EL PASO COUNTY GRADING AND EROSION CONTROL PLAN CHECKLIST

EPC Project Number: PUDSP-22-005

CHALLENGER HOMES
FALCON HIGHLANDS SOUTH
EL PASO COUNTY, COLORADO
CONSTRUCTION PLANS
GRADING AND EROSION CONTROL PLAN
INITIAL GECP

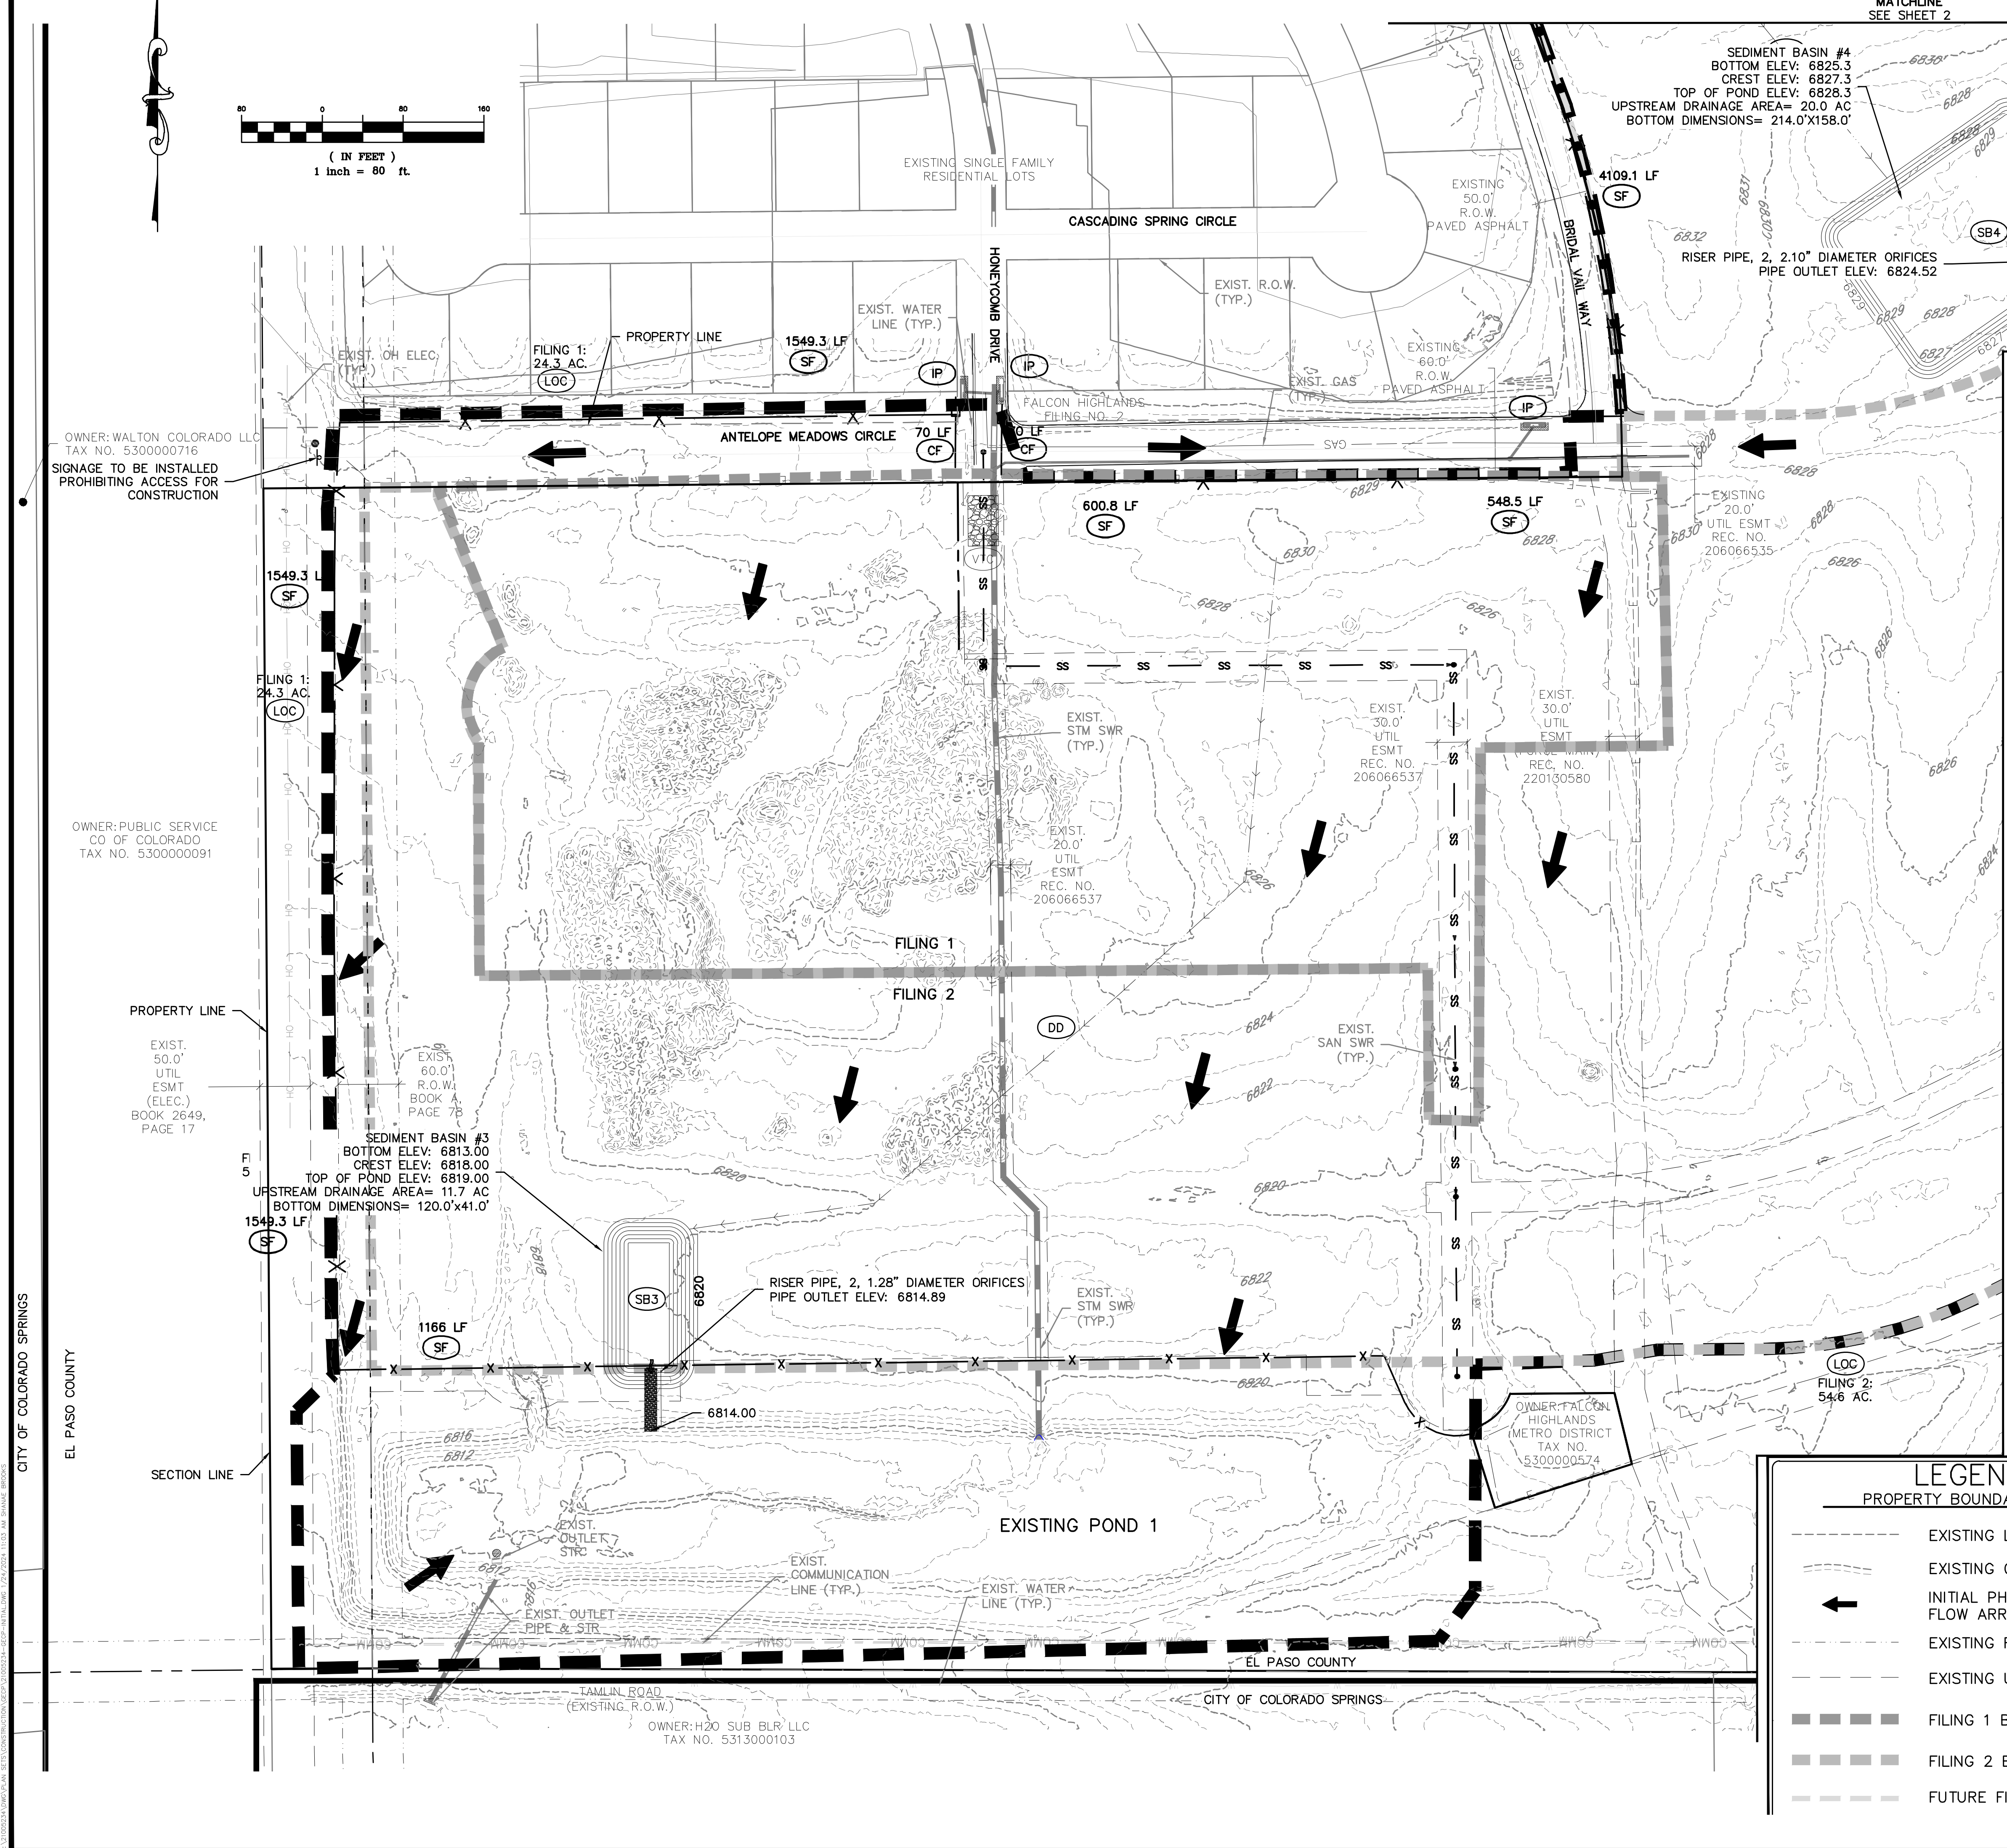
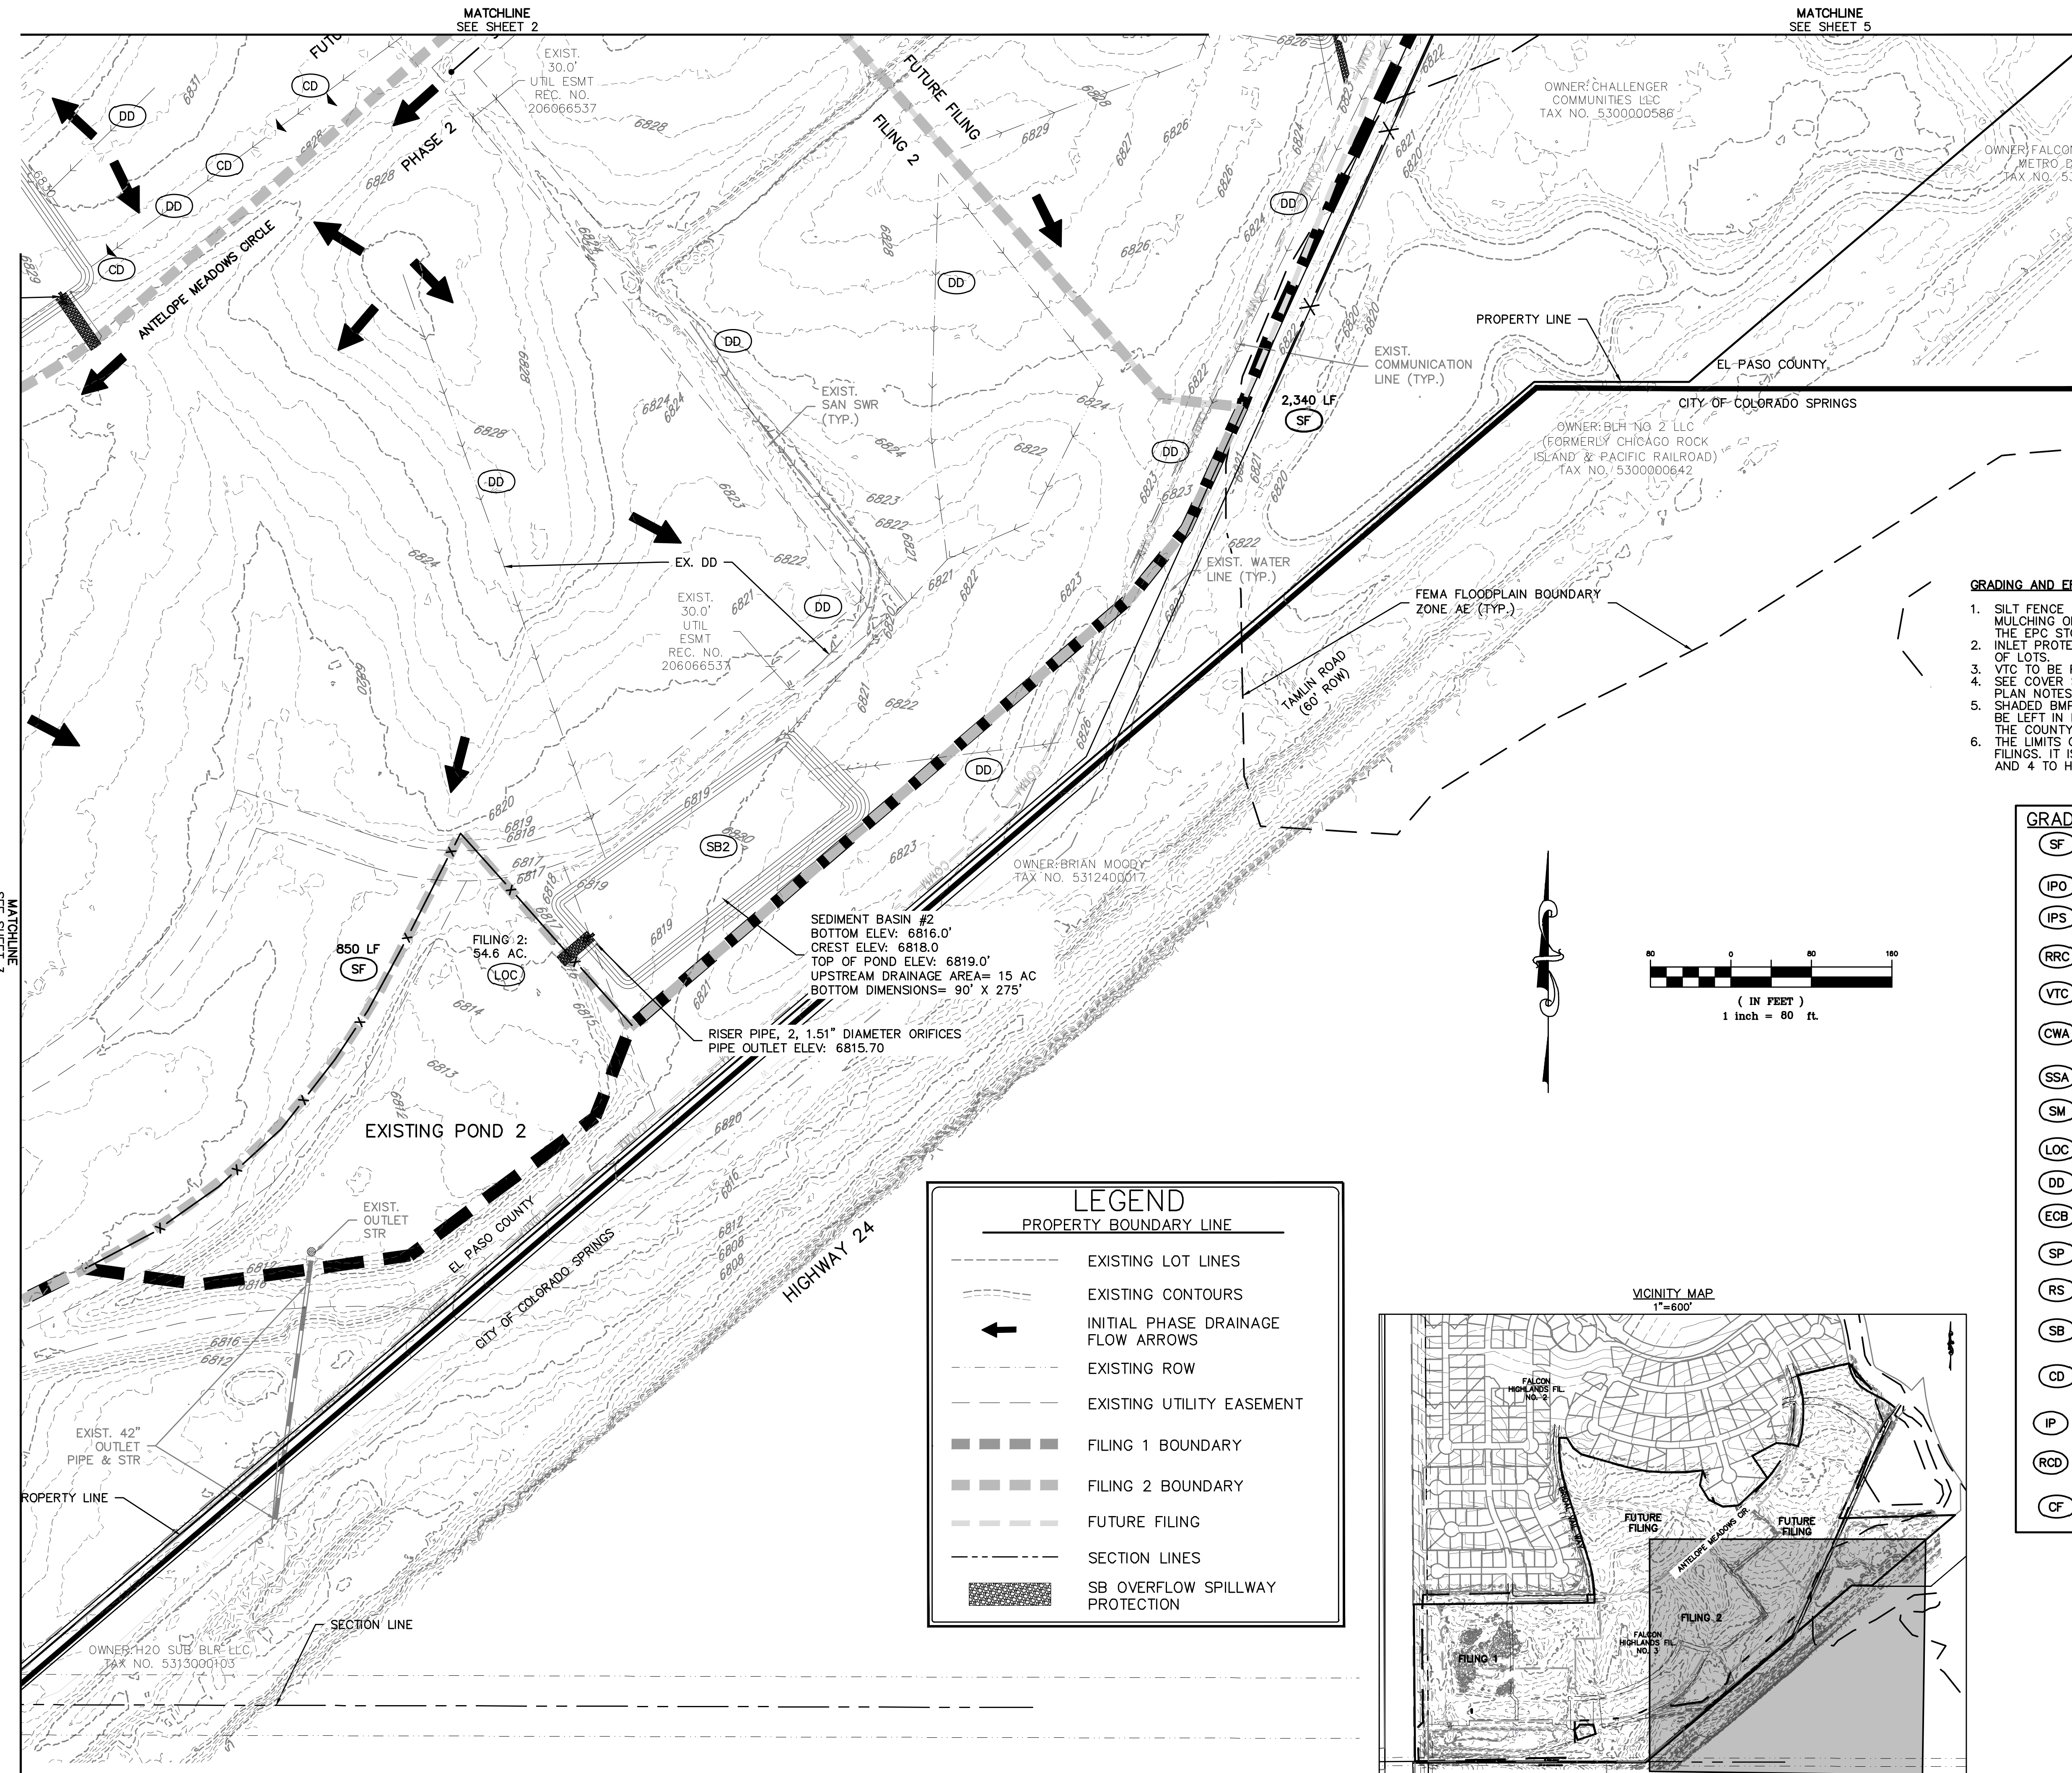
l	Existing and proposed contours 2 feet or less (except for hillside)		✓
m	Limits of disturbance delineating all anticipated areas of soil disturbance		✗
n	Identify and protect areas outside of the construction site boundary with existing fencing, construction fencing or other methods as appropriate		✗
o	Off-site grading clearly shown and called out		N/A
p	Areas of cut and fill identified		✓
q	Conclusions from soils/geotechnical report and geologic hazards report incorporated in grading design (slopes, embankments, materials, mitigation, etc.)		✓
r	Proposed slopes steeper than 3:1 with top and toe of slope delineated. Erosion control blanketing or other protective covering required		✓
s	Stormwater flow direction arrows		✓
t	Location of any dedicated asphalt / concrete batch plants		N/A
u	Areas used for staging, storage of building materials, soils (stockpiles) or wastes. The use of construction office trailers requires PCD permitting		✓

v	All proposed temporary construction control measures, structural and non-structural. Temporary construction control measures shall be identified by phase of implementation to include "initial," "interim," and "final" or shown on separate phased maps identifying each phase		✓
w	Vehicle tracking provided at all construction entrances/exits. Construction fencing, barricades, and/or signage provided at access points not to be used for construction		✗
x	Temporary sediment ponds provided for disturbed drainage areas greater than 1 acre		✓

4. APPLICANT COMMENTS			
a			✗
b	this does not match the TSB locations shown on the GEC		
c
